Planning and Urban Development Department

Subject: R-6 Small Infill Design Review – 30 Merrill Street

Written by: Caitlin Cameron, Urban Designer

Date of Review: Wednesday, August 7, 2016

DRAWN BY EMW
 SHEET TITLE 4TH & ROOF

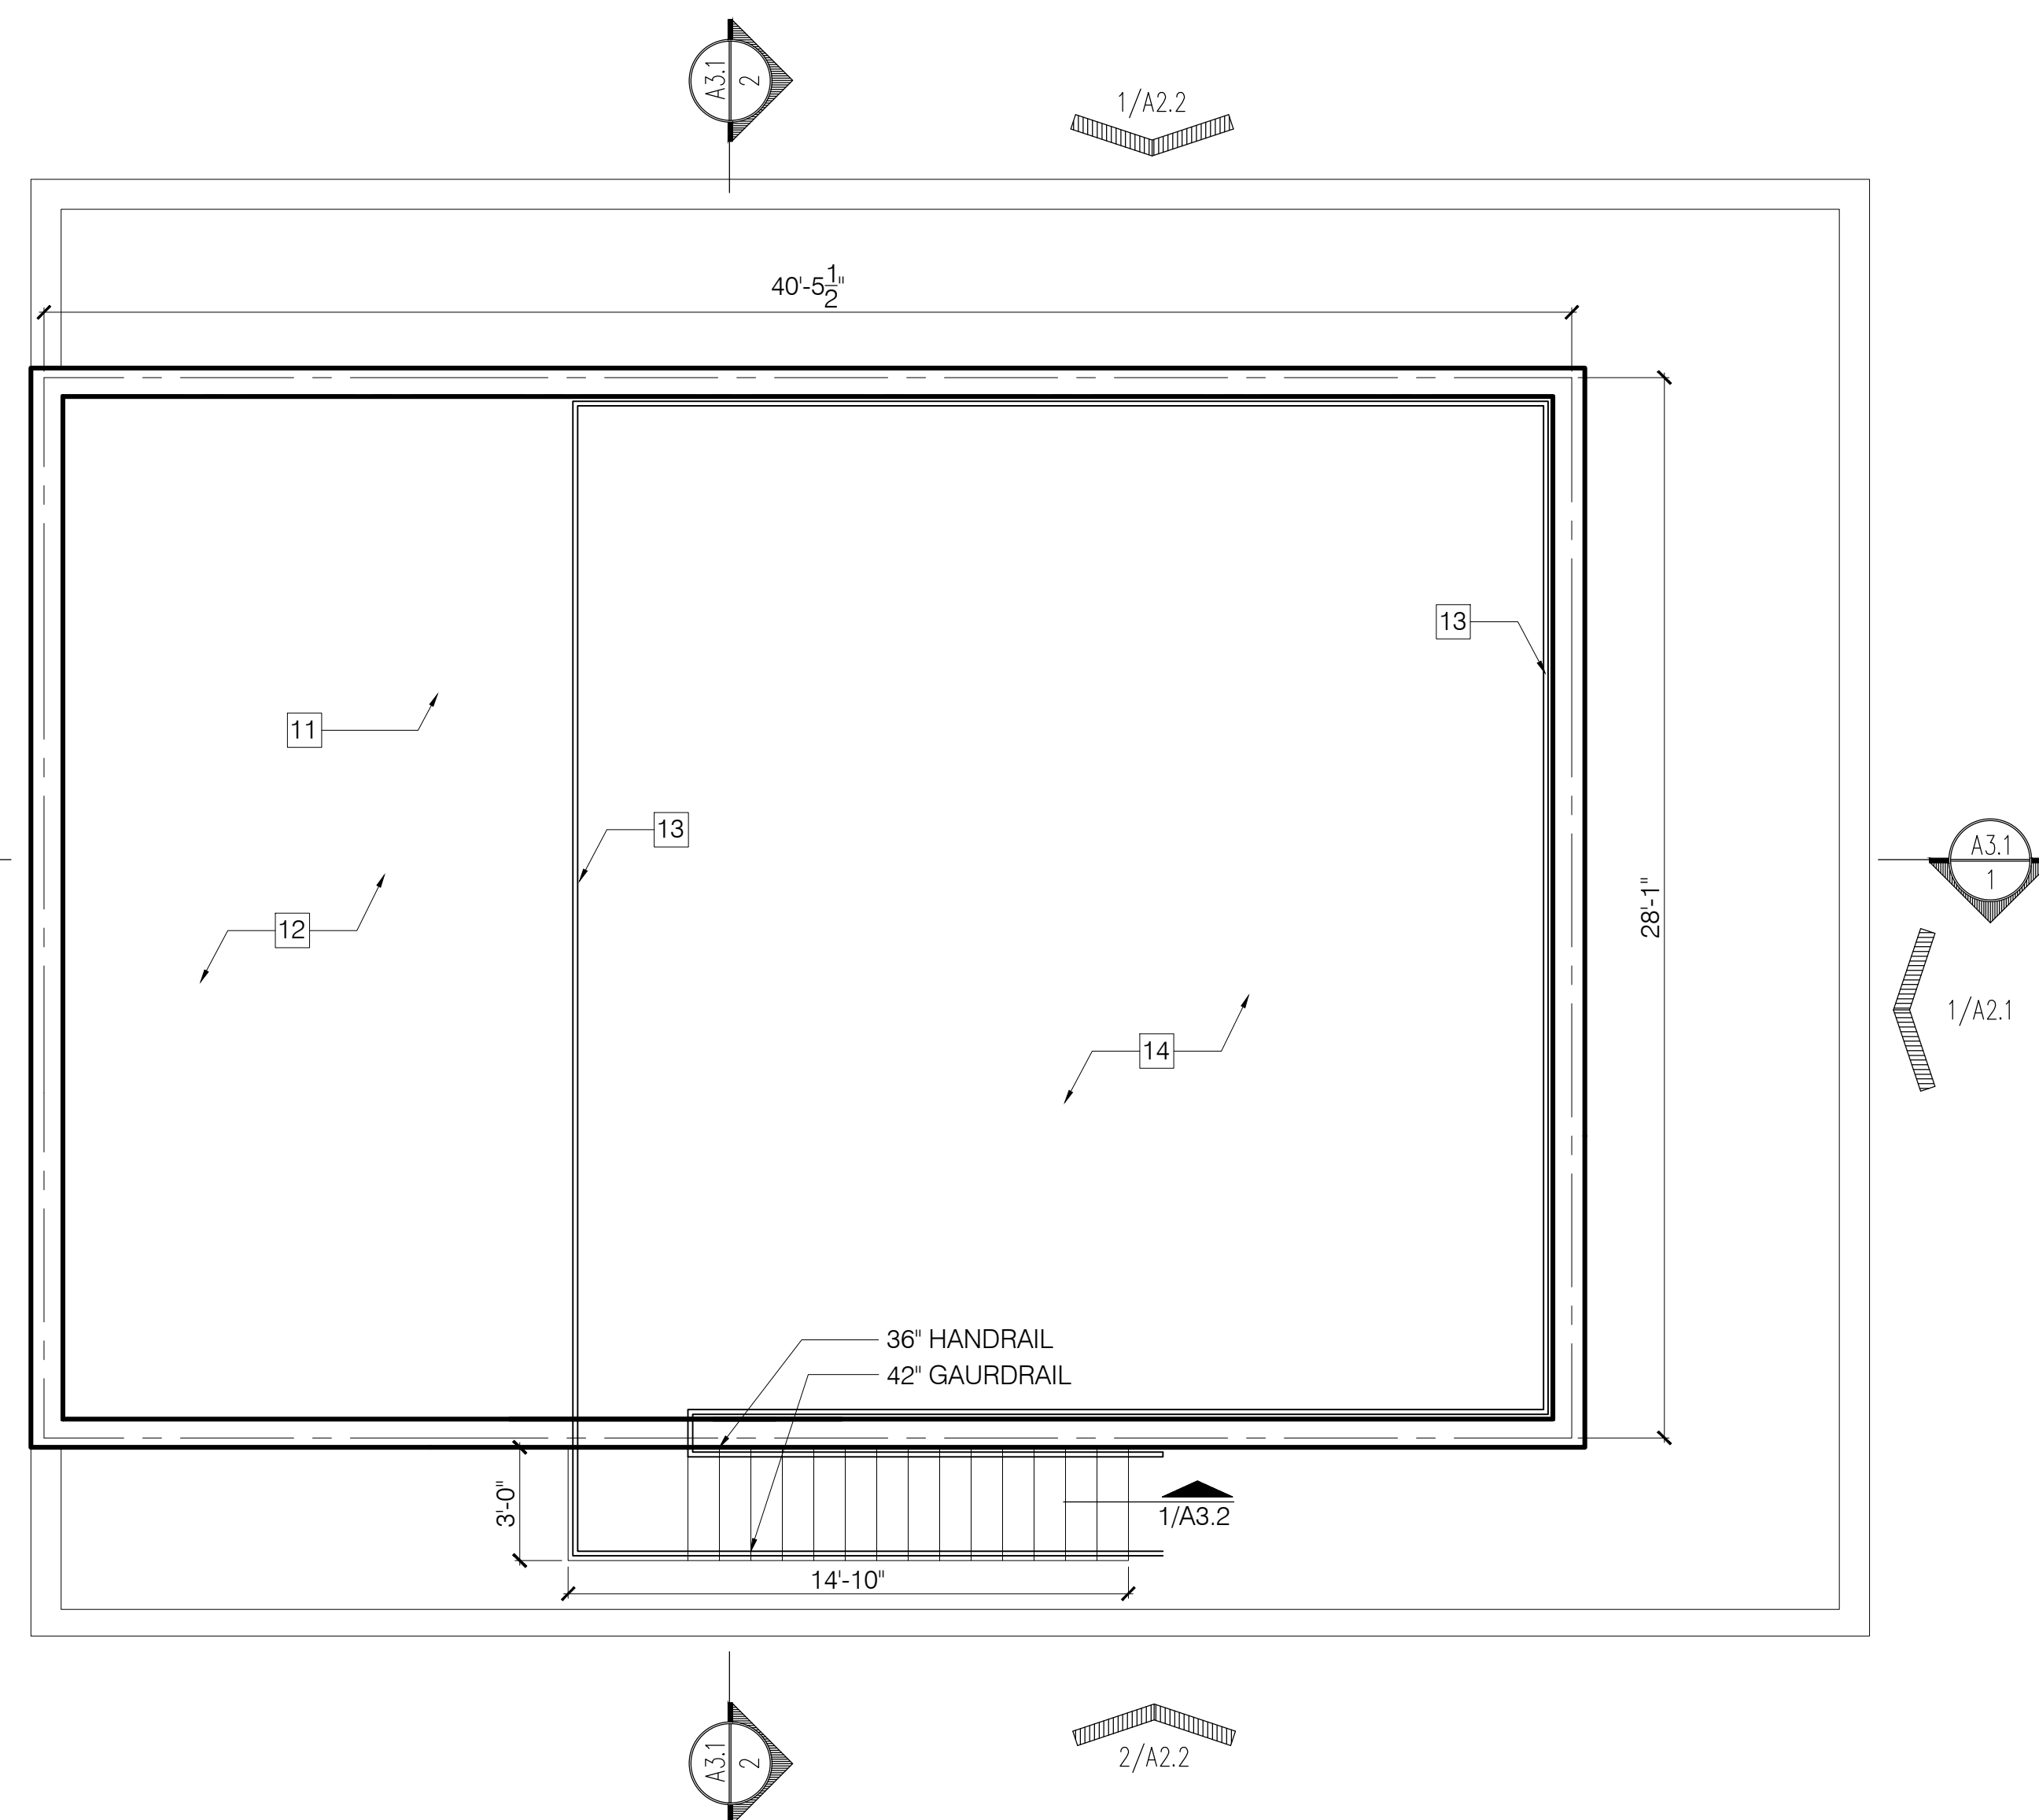
- *B-1 Massing:* The mass of this building is very boxy and simple without the typical tools employed to create a visually interesting, human-scaled residential building. The 7th unit on the fourth floor is not set back and adds to the impression of scale at the street. To become contextual, the building massing needs to be revised (stepback at 4th floor, offsets, bays, etc.).
- *B-2 Roof Forms:* The proposed 7th unit on the top floor creates an awkward “roof form” – the top unit should be stepped back from the principal façade so that the flat roof form of the primary building mass is dominant.
- *B-4 Roof Pitch:* The roofs are monopitch/ flat roofs.
- *B-5 Façade Articulation:* The project employs two of the required articulation elements – covered entry, balconies.
- *B-6 Garages:* Not applicable.
